From: Martyn White
Sent: 07 December 2018 14:31
To: Planning.Responses
Cc: Anita Gardner
Subject: AB/101/18/L

AB/101/18/L

The application is for Listed Building consent to replace 2 No. front bay windows to the front of the property. I also note that there is reference to guttering (contrary to the application description) on a like for like basis.

Proposed Sections
Box Frames & Joints
(For S4 Tamaraut St.)
(Armedel, BN18 9DN)
BAT WINDOW
FRONT

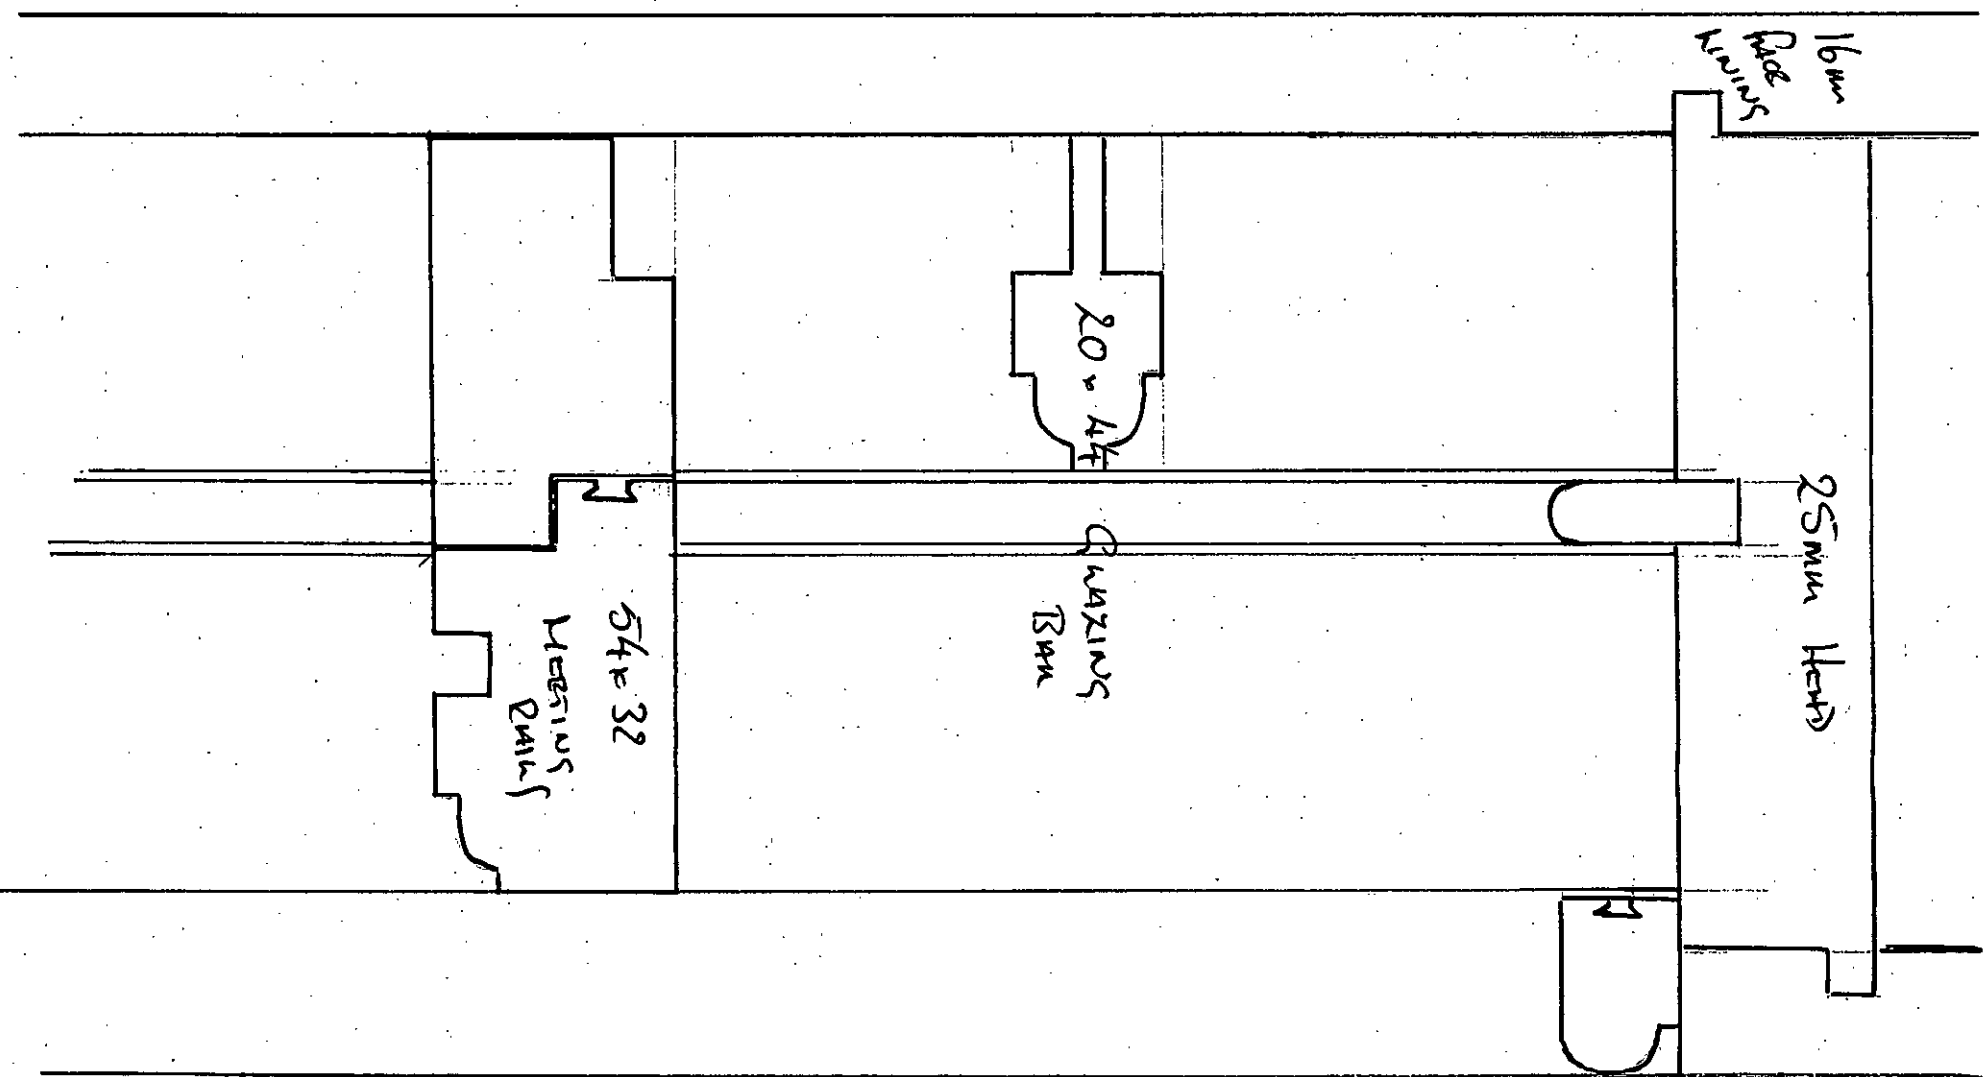
Good practice is that the existing windows should be repaired prior to wholesale replacement, as is proposed here. I note that the agent for the application is indicating that the windows are beyond repair and should be replaced in their entirety. As the windows will be replaced on a like-for like basis, it is considered that that such an application can be supported in this instance.

Front elevation
of 54 Tavant St.
showing 2 bay windows
one above the other
to be replaced.

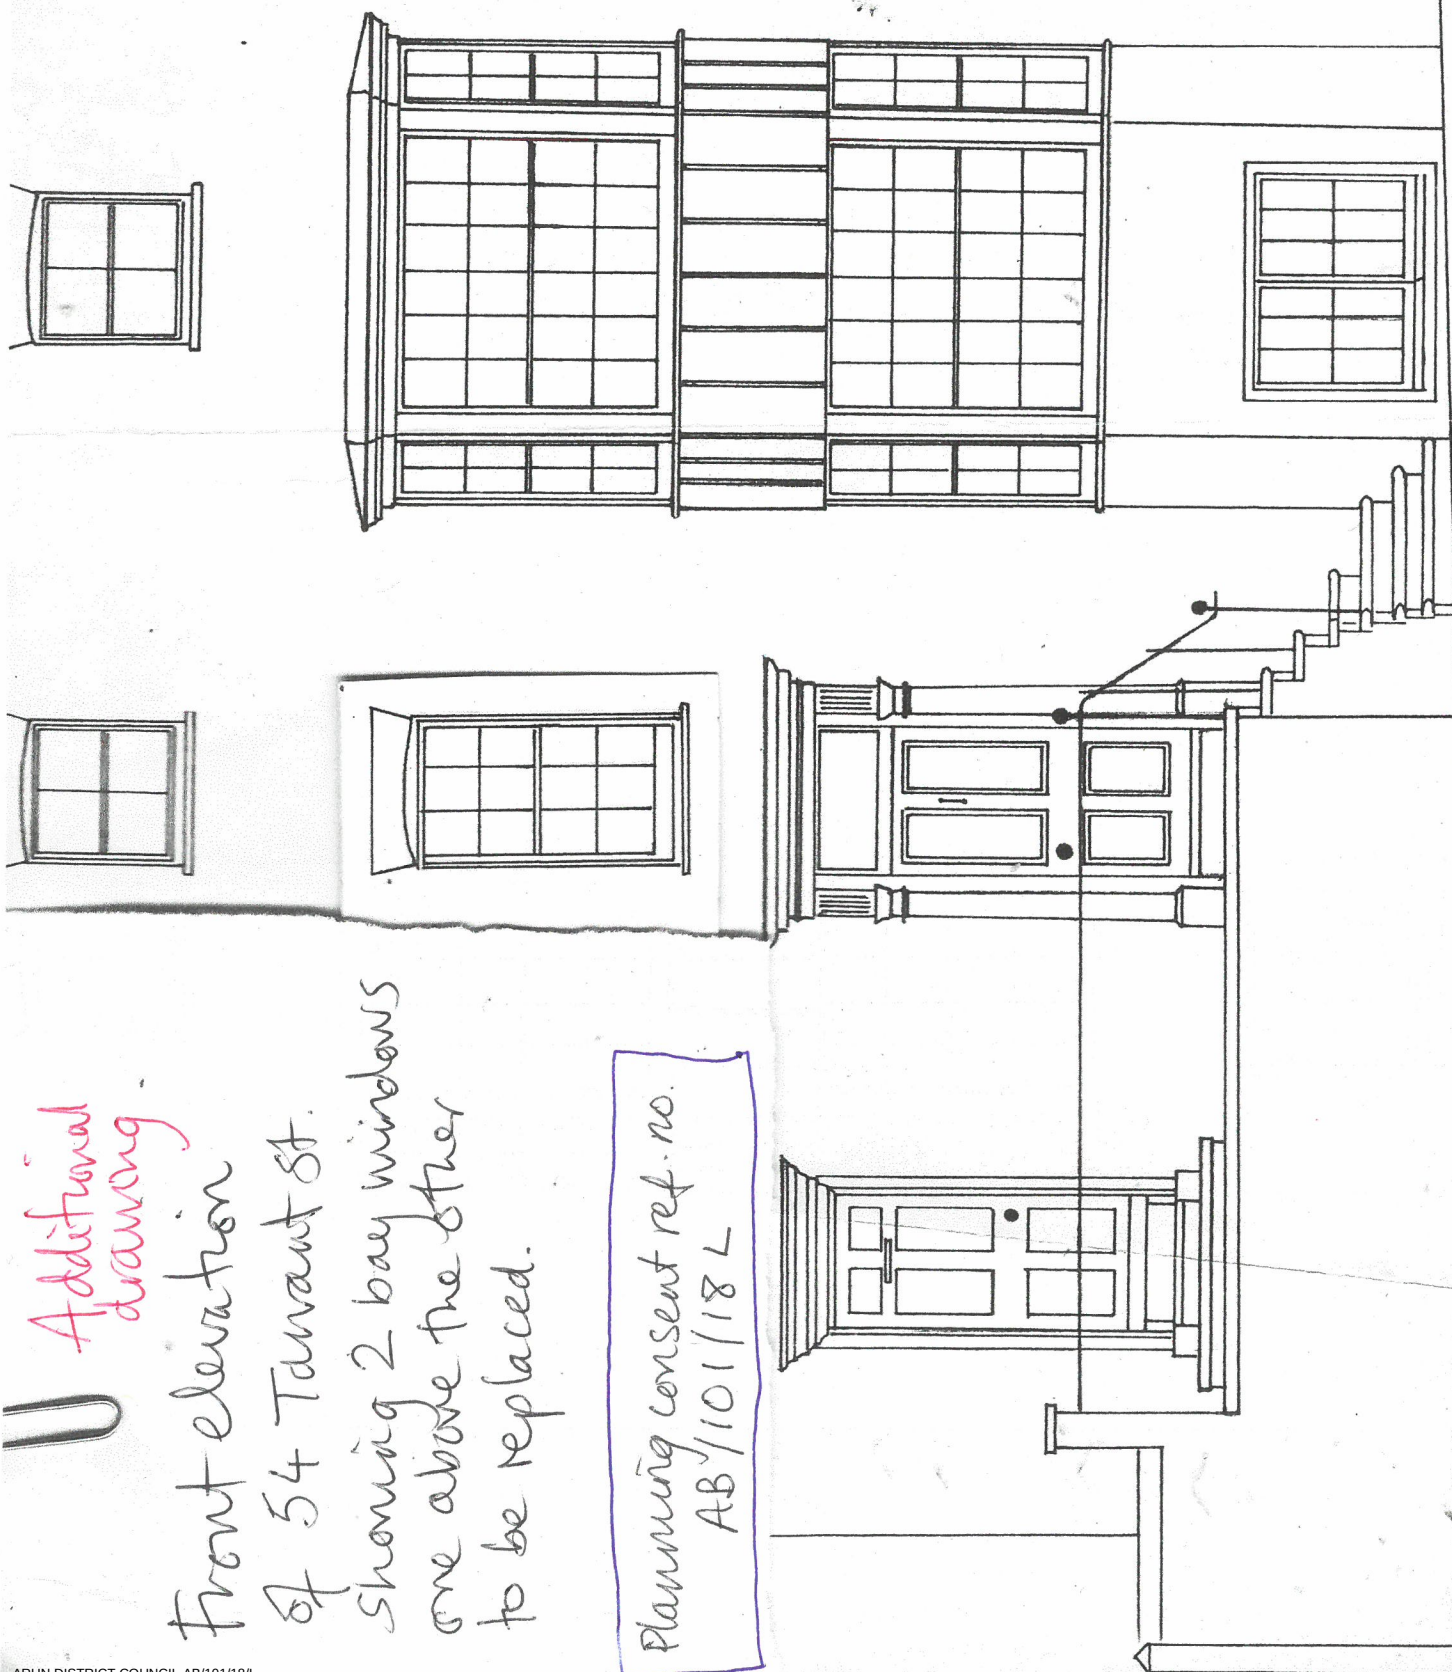
With respect to the guttering, I am concerned that there does not appear to be any attempt to improve what exists on the front elevation. Whilst I note that the existing guttering is constructed from UPVC, the use of a more appropriate material would be preferred. Such an approach is evident on other properties within the conservation area.

Further, reference is made with the statements that the windows will be painted 'Little Greene Mid Lead'. It is assumed that this colour will be a direct like-for-like colour match of the existing colour. If this is different from the existing colour, how will this affect the remaining windows on the rest of the elevation/property? If there is a change in colour proposed, a listed Building Consent application will be required to re-paint the remaining windows.
